**WEST SUSSEX COUNTY COUNCIL
PRE-APPLICATION CONSULTATION**

TO:	Organisation: Highgate Transportation FAO: Alice Howse and Fiona Bennett
FROM:	WSCC - Highway Authority
DATE:	20 October 2025
LOCATION:	Land North of Summer Lane Summer Lane Pagham PO21 4FE
SUBJECT:	Internal Reference: PRE-80-25 Circa 110 residential dwellings on Land to the North of Summer Lane, with circa 50 dwellings to be accessed via Summer Lane, and circa 60 dwellings to be accessed via the recently approved site P/35/24/OUT
DATE OF SITE VISIT:	15 September 2025
RECOMMENDATION:	Advice
S106 CONTRIBUTION TOTAL:	TBA at planning application stage

**Land North of Summer Lane
Summer Lane
Pagham
PO21 4FE**

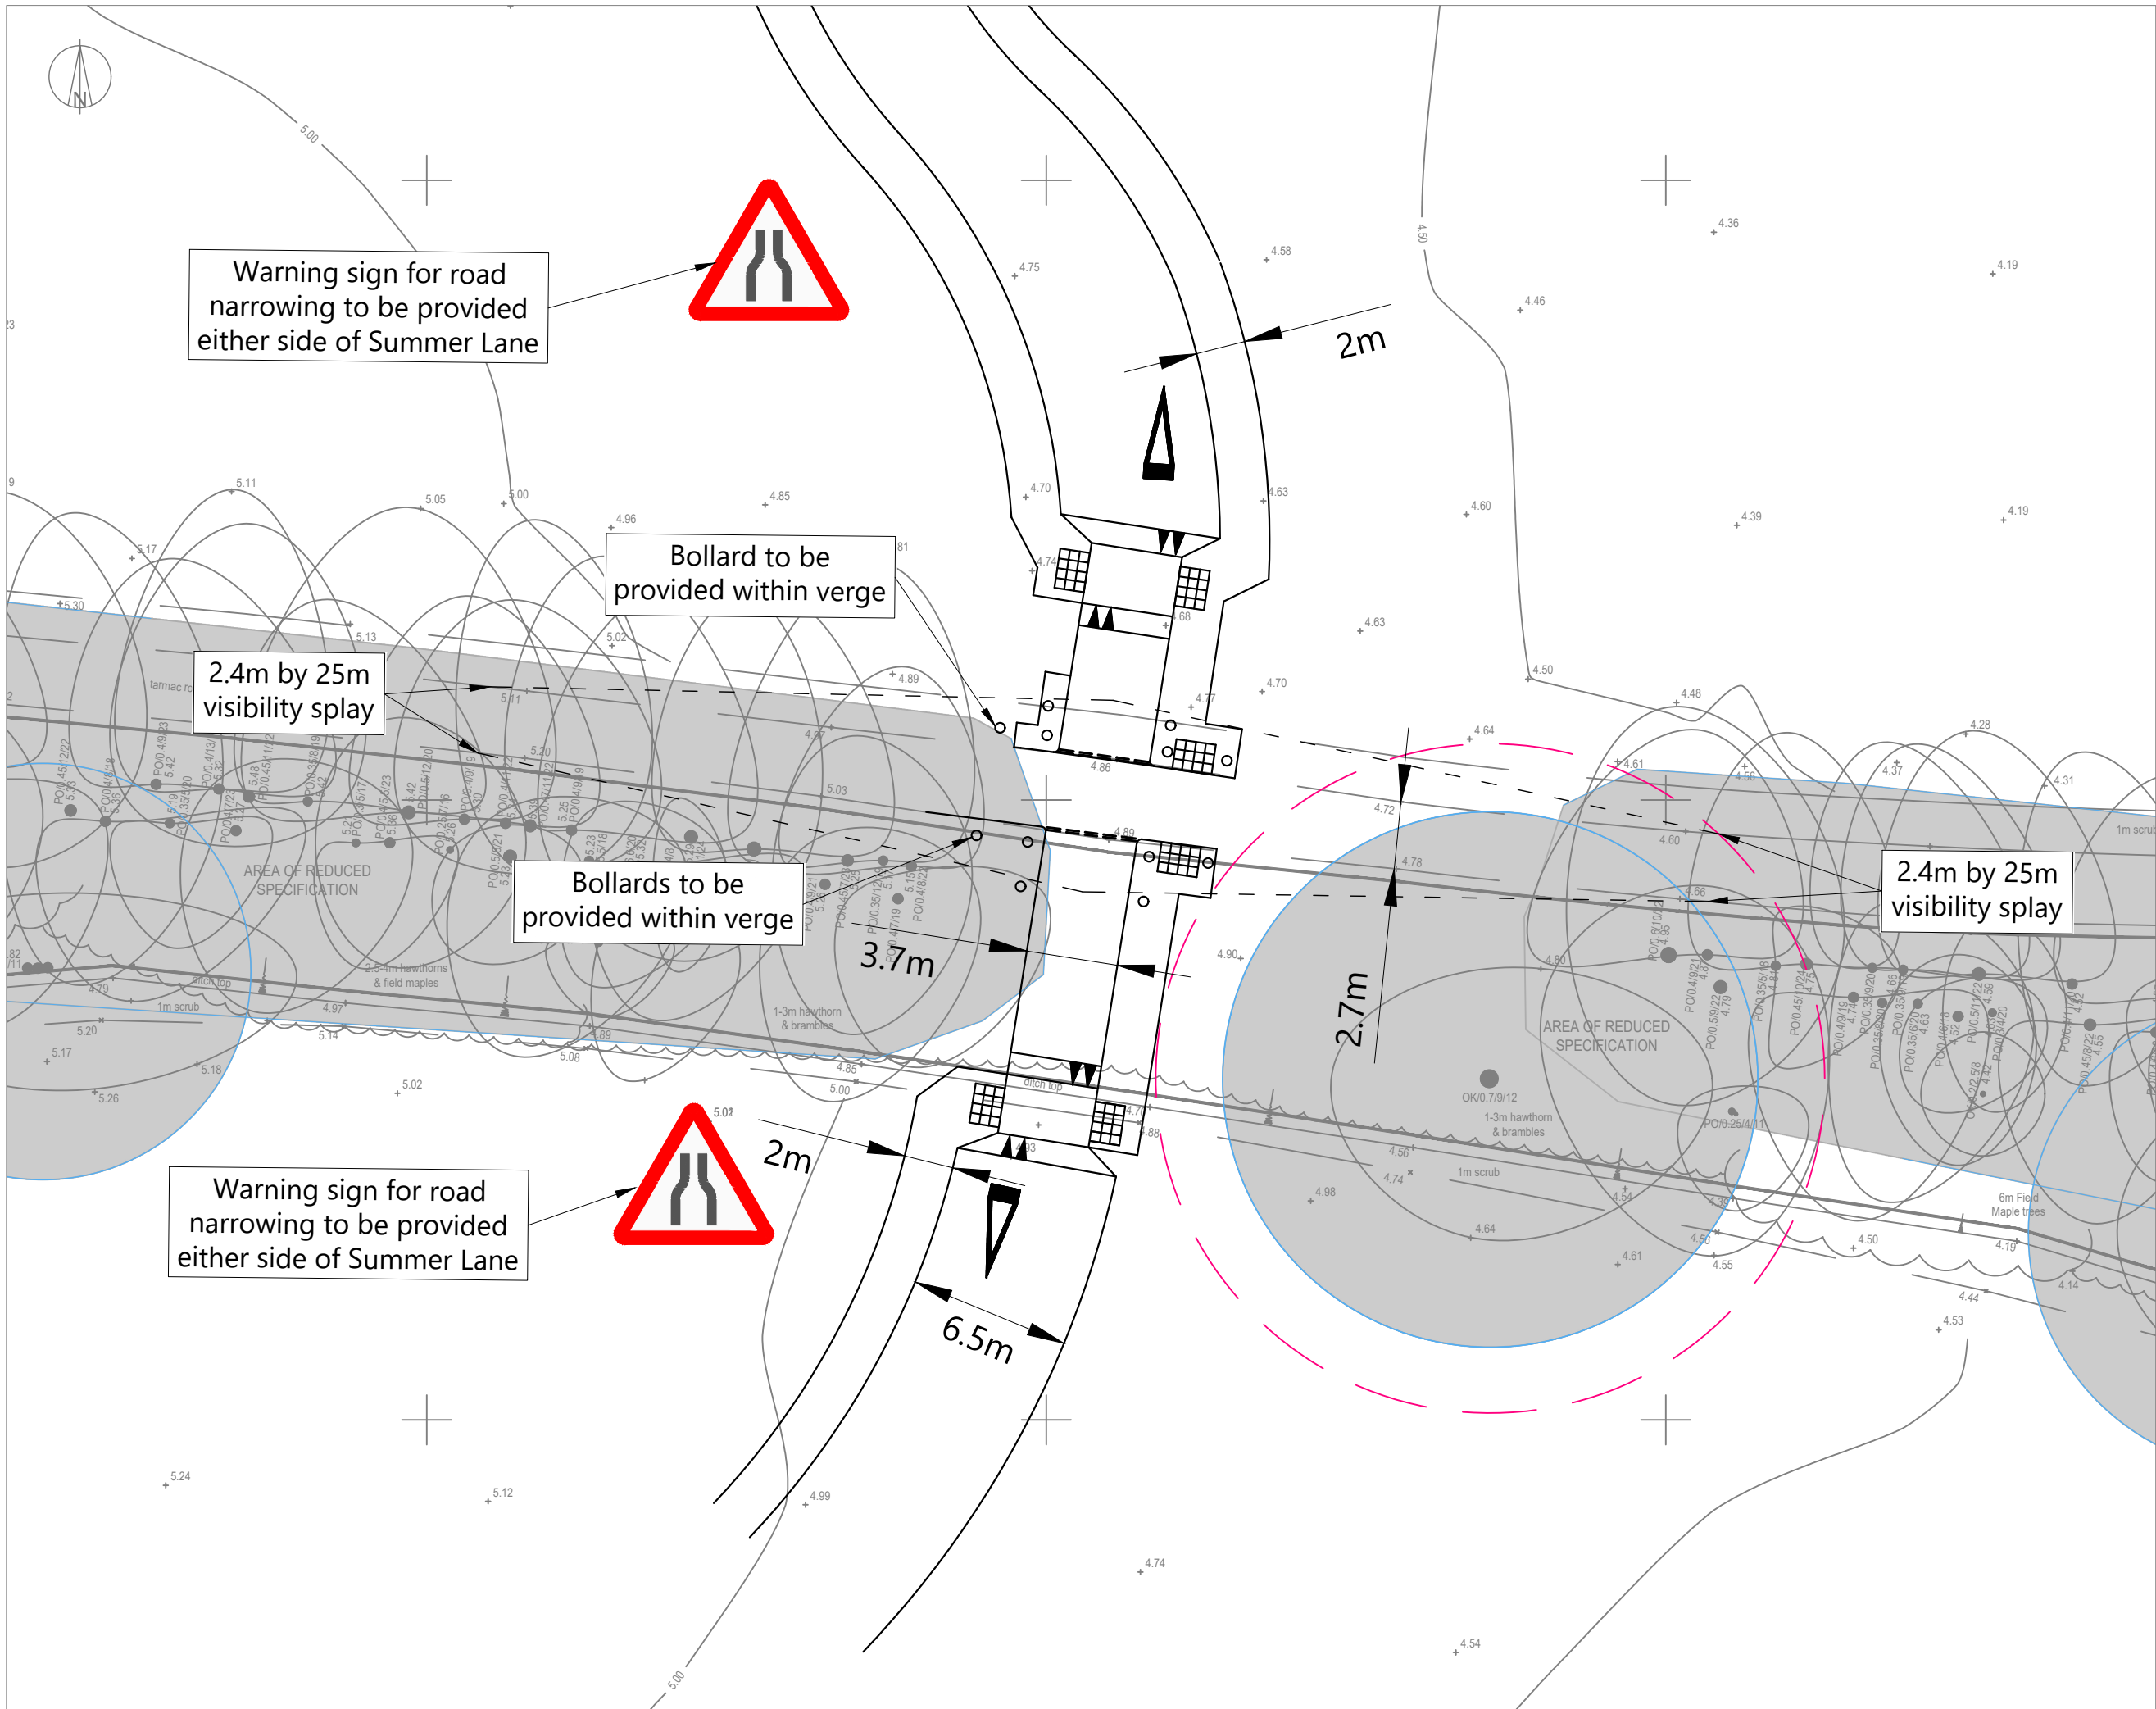
- iv. A review of the recent personal injury road traffic collisions – *To be included in the TA.*
- v. The design of the proposed access from Summer Lane for 50 dwellings – *The alignment of the intersection with Summer Lane is a bit tortuous and will require drivers to look back at an acute angle. However, having it with priority into the development is likely to work better as if the access were to give-way to Summer Lane, it is likely that drivers wouldn't give way, given the status of Summer Lane as a (to be) Bridleway with its infrequent traffic movements. How speeds will be controlled at this point should be demonstrated. And, the bend will need slight widening to allow large vehicles to negotiate. It is also recommended that a form of speed control be provided at certain points along the new access road serving the 50 dwellings in an attempt to manage traffic speeds to the 20mph proposed. There is also the requirement to ensure visibility splays are provided from adjacent junctions and accesses onto any reconfigured road and also at the point it interfaces with Summer Lane. Regarding Figure 3.1, the bellmouth radii here should not be shown with one side being acute as there will be the need to traverse westwards for some – particularly refuse collection. Recommend MfS be used to inform the resultant bellmouth radii. Please also see PRow comments below.*

- vii. The design of the proposed access through approved land south of Summer Lane – *As shown (6.5m wide), WSCC consider this to be too wide and could encourage excessive speed. As such, it should be narrowed. Also, WSCC would want to see at least one footway provided alongside it linking both the development the development south of Summer Lane with it. The route should also give-way to Summer Lane to ensure priority for the PRow (Summer Lane). Forms of speed control should be provided on the road link as well as appropriate levels of visibility splays for all users converging at the crossing point. The final design should be such that it prevents abuse of the control methods to stop motorists using Summer Lane and rat-running. Street lighting should be provided for the location and overall scheme including junctions and access routes serving it.*

- 4. Where the road crosses the PRoW, the safety of PRoW users must be a priority. The current proposed width of 6.5m might allow for unacceptable speeds at this point. The area must be well lit, vehicles must be prohibited from turning left or right, have sufficient visibility to see PRoW users approaching from both directions, have signage to warn them of PRoW users and be subject to some Give Way system.*

- 5. Where the access road into the development joins Summer Lane, PRoW team is concerned that there is insufficient consideration given to the safety of PRoW users. Vehicles emerging from the development will be travelling along a continuous road into Summer Lane and have highway priority. Eastwards-bound PRoW users will be crossing a road to continue onwards. This in itself isn't necessarily a problem, particularly given the predicted traffic volume but a Safety Audit to consider the safety of PRoW users at this point and any necessary safety measures implemented needs to be undertaken and provided to WSCC for comment.*
